Awel y Môr Offshore Wind Farm

Planning Inspectorate reference:
EN010112

Summary of Written Representation
for Examination Deadline 1 by
Gwynedd Archaeological Planning Service

24th October 2022

Drawing file: published-documents / EN010112-000380-6.6.10.5.17_AyM_SLVIA_Fig_44a-g_VP17_Penrhyn_Castle_terrace.pdf

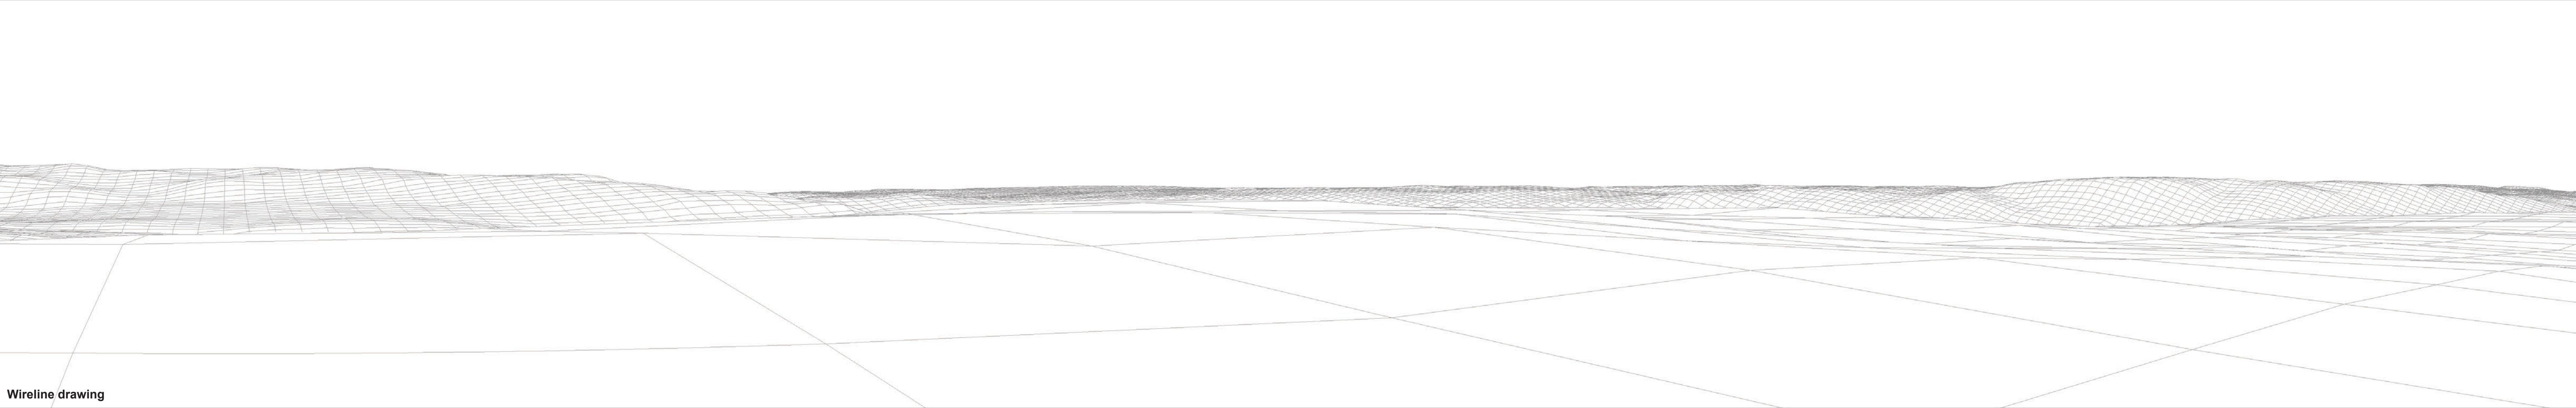
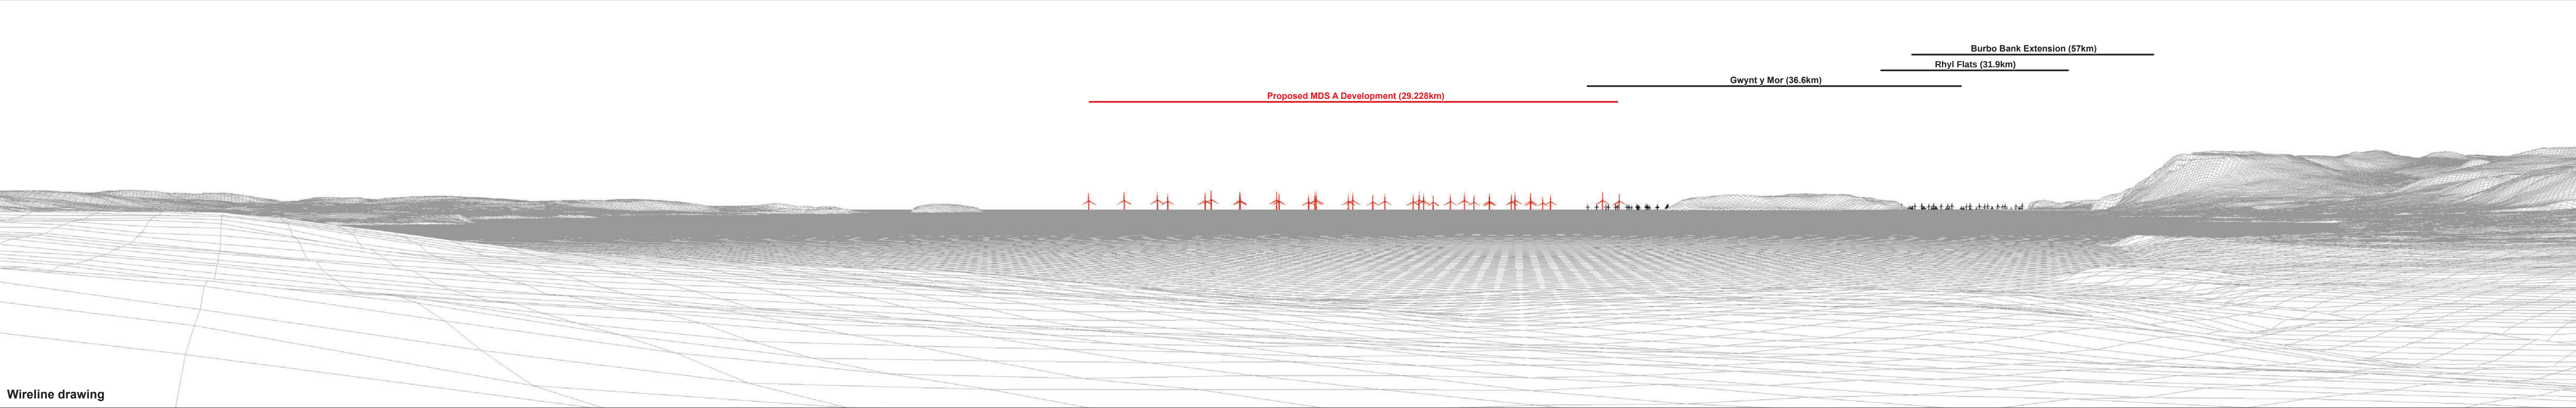
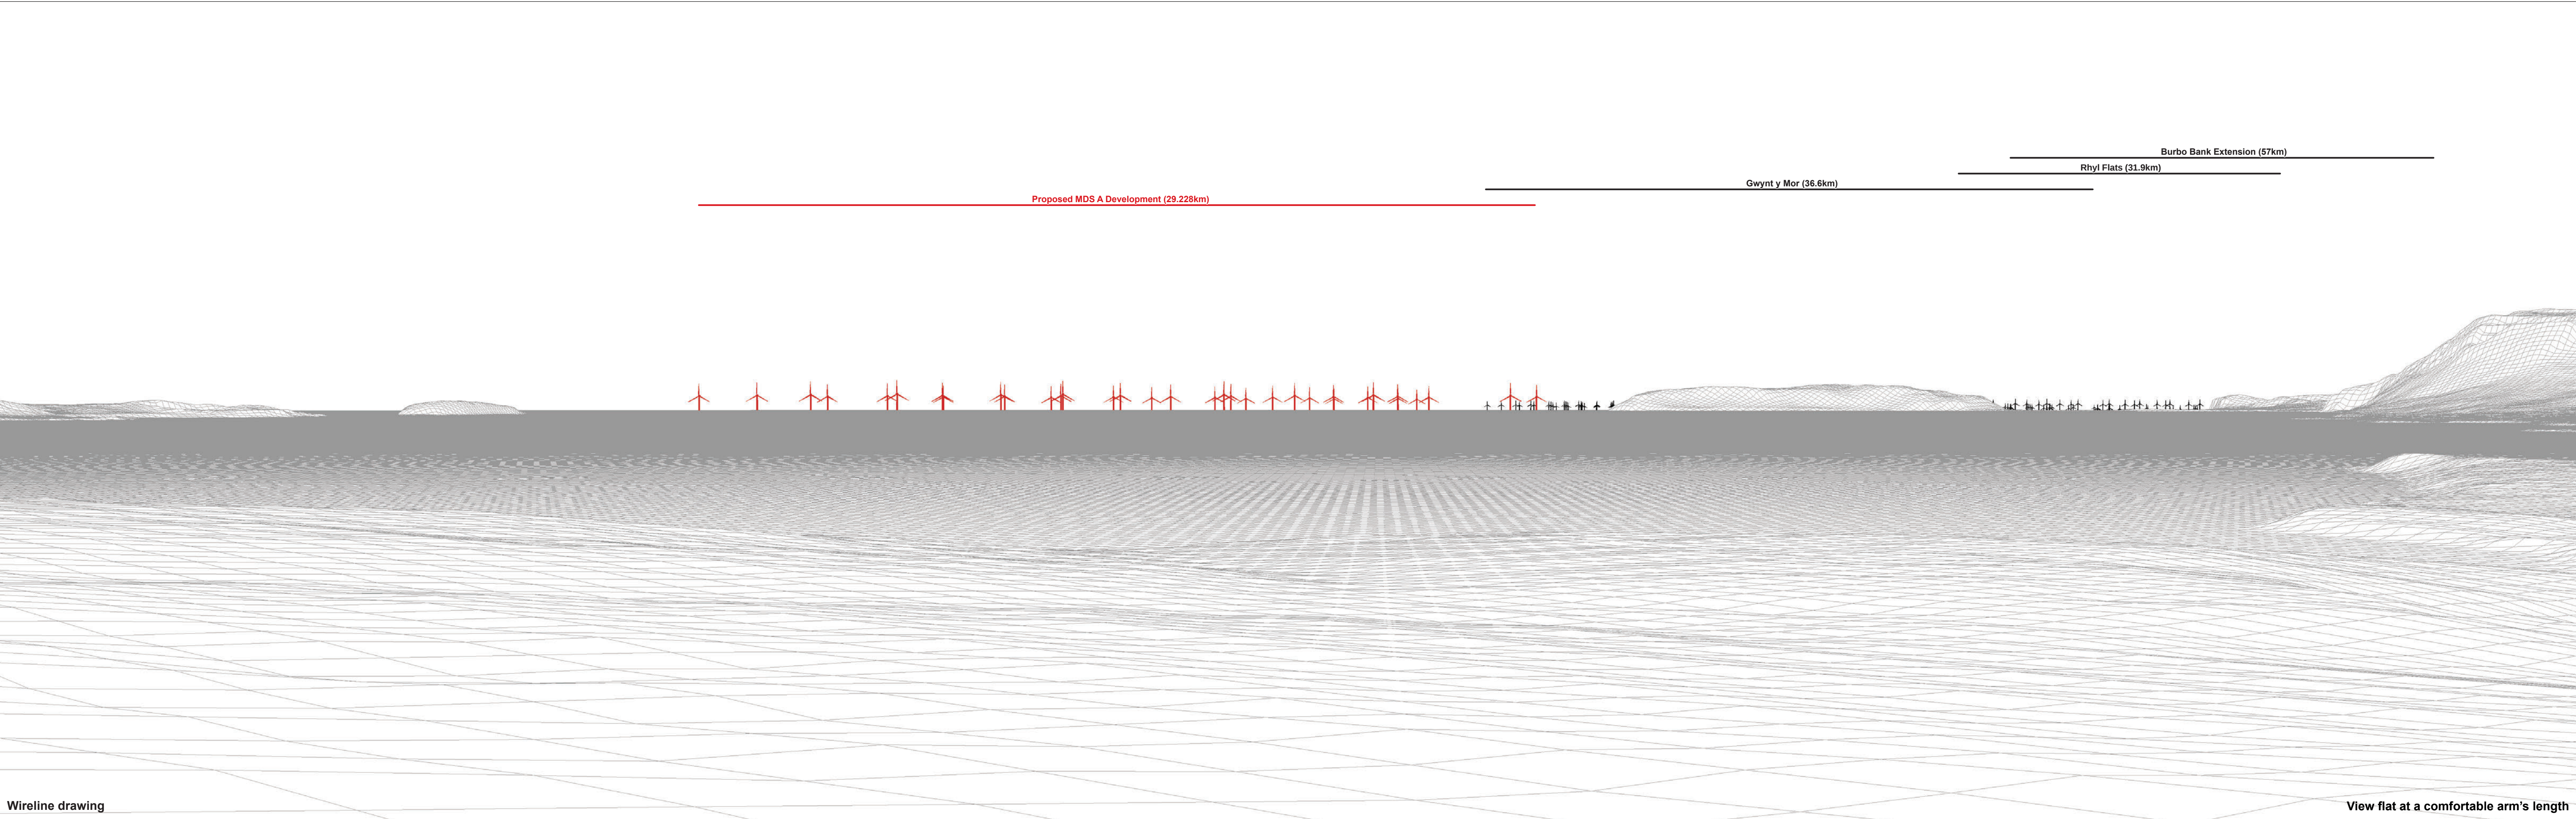
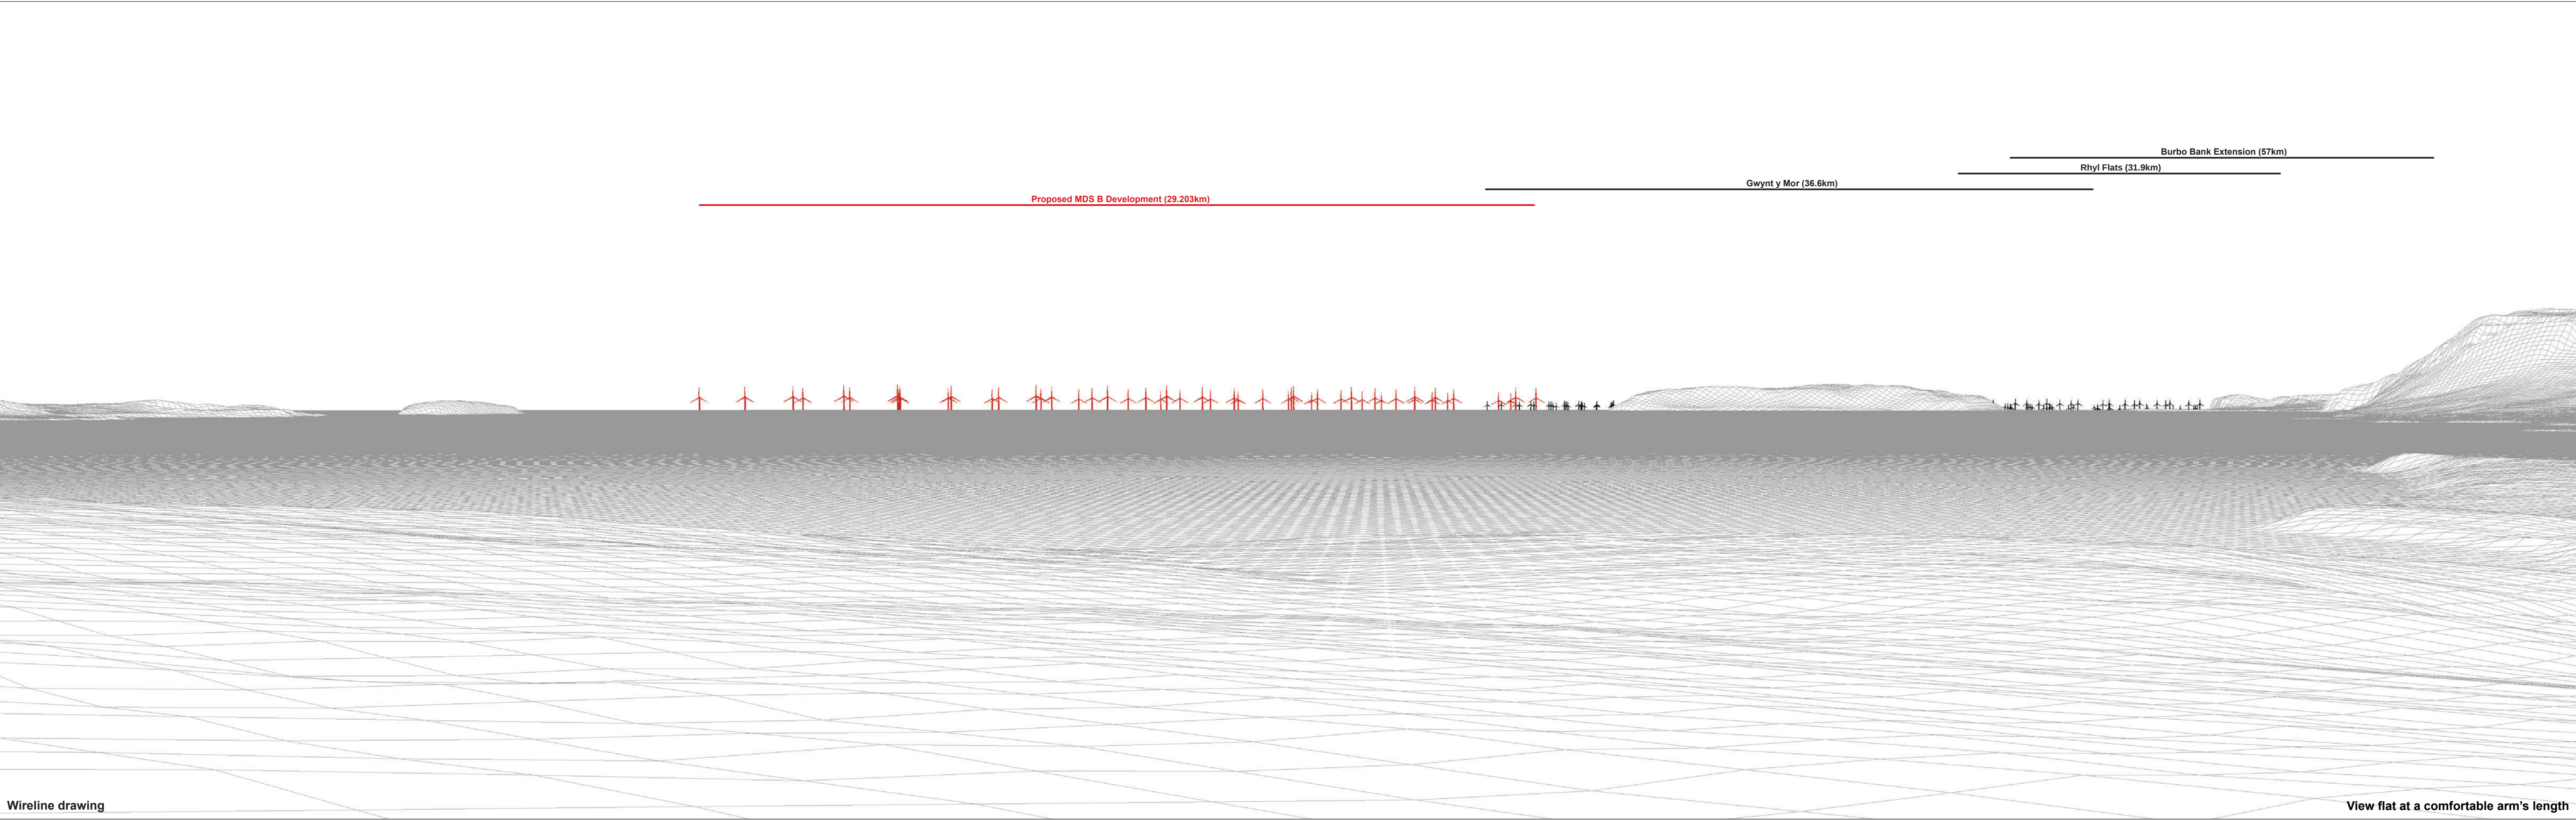
- 2.24 VP17 (Volume 6, Annex 10.5, Fig.44) illustrates this view and is discussed in Volume 2, Chapter 10 SLVIA Table 6. It is shown that the proposed development would extend offshore wind farm development within a framed view across the visible seascape skyline, with the Awel y Môr turbines noticeably taller and more prominent than existing developments. The SLVIA assesses the impact as moderate (significant), taking account of factors increasing the capacity of the view to accommodate new wind turbines, such as topography.

- 2.25 Natural beauty and visitor experience influence the contribution of setting to significance principally in the case of designed and formal vistas. This is considered to be applicable here. The new wind turbines would be conspicuous and intrusive in the view from the terrace, drawing the eye away from the intervening grounds, reducing the prominence of the Great Orme headland, and removing the sense of openness of an undeveloped sea horizon. This would materially reduce the aesthetic value of this view and thereby the contribution that this part of the setting makes to the significance of the Registered Park and Garden. It is considered that this would be a medium impact of moderate significance.

Drawing file: published-documents / EN010112-000408-6.6.10.5.45_AyM_SLVIA_Fig_72a-c_VP45_Conwy_Castle_–_Chapel_Tower.pdf

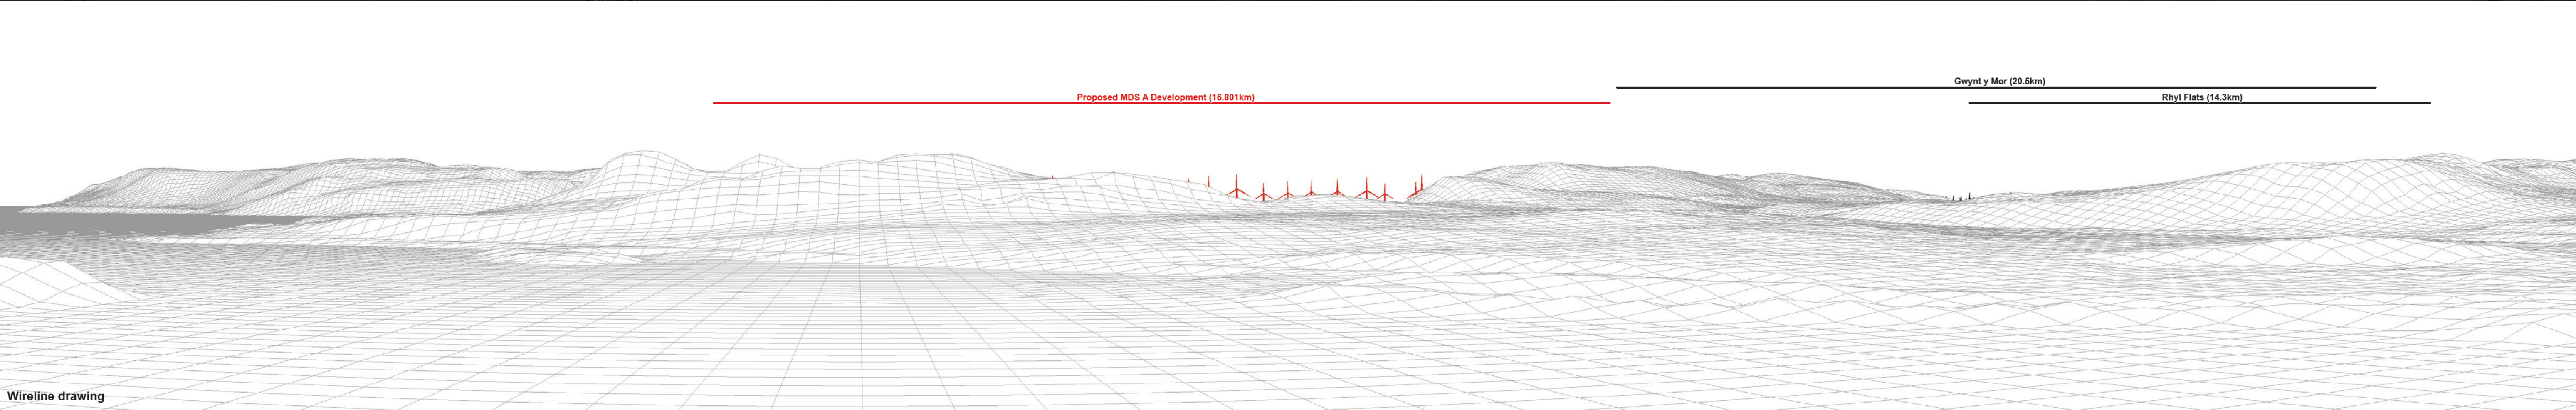
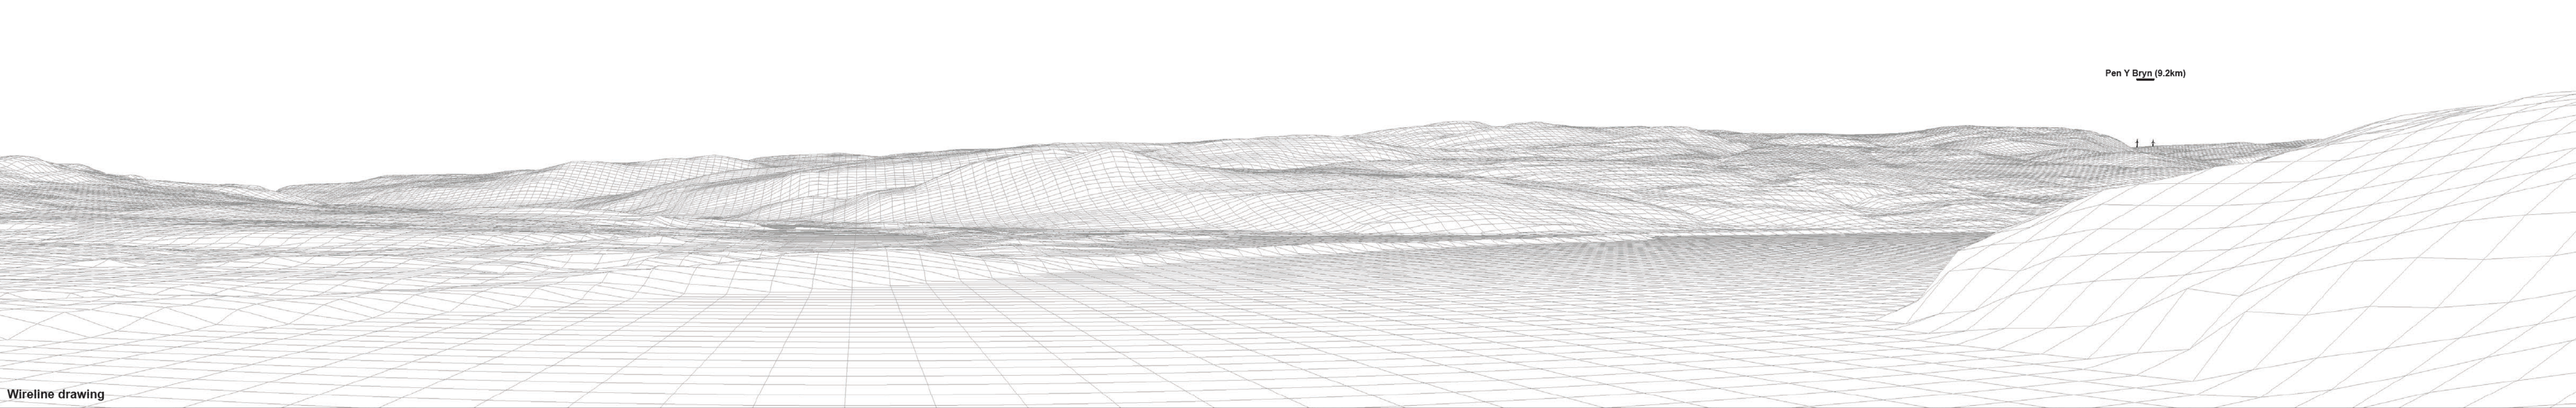
- 2.17 The assessment focuses on views from the castle with no discussion of views from the town walls, and as such could be argued to be incomplete. VP45 from the Chapel Tower of the castle has been selected as representing the view from the castle with maximum visibility of the proposed development. The view in this direction from the highest point on the Town Walls, the Watchtower, is likely to be similar, and VP45 can therefore be taken as representative of the Conwy component of the World Heritage Site.

- 2.18 Volume 6, Annex 10.5, Fig.72b illustrates the visibility of parts of up to 16 turbines on the skyline in a dip between hills. This is part of an identified significant arc of view in the World Heritage Site Management Plan⁵, but is not identified as being of specific interest, in contrast to views along the estuary, for example. Nonetheless, the turbines are incongruous and detract from the aesthetic quality of this view. In relation to significant views, the World Heritage Site Management Plan states that “Inappropriate development or change is considered to be that which would obstruct or interfere with or distract from these views” (paragraph 2.4.2). As scenic quality in this part of the view acts to enhance the experience and appreciation of the World Heritage Site, rather than being of intrinsic importance, the turbines are considered to be a small distraction within the wider arc of view. Having regard to the very high status of the monument, it is considered that this constitutes an impact of negligible/low magnitude, minor significance and not significant in EIA terms.
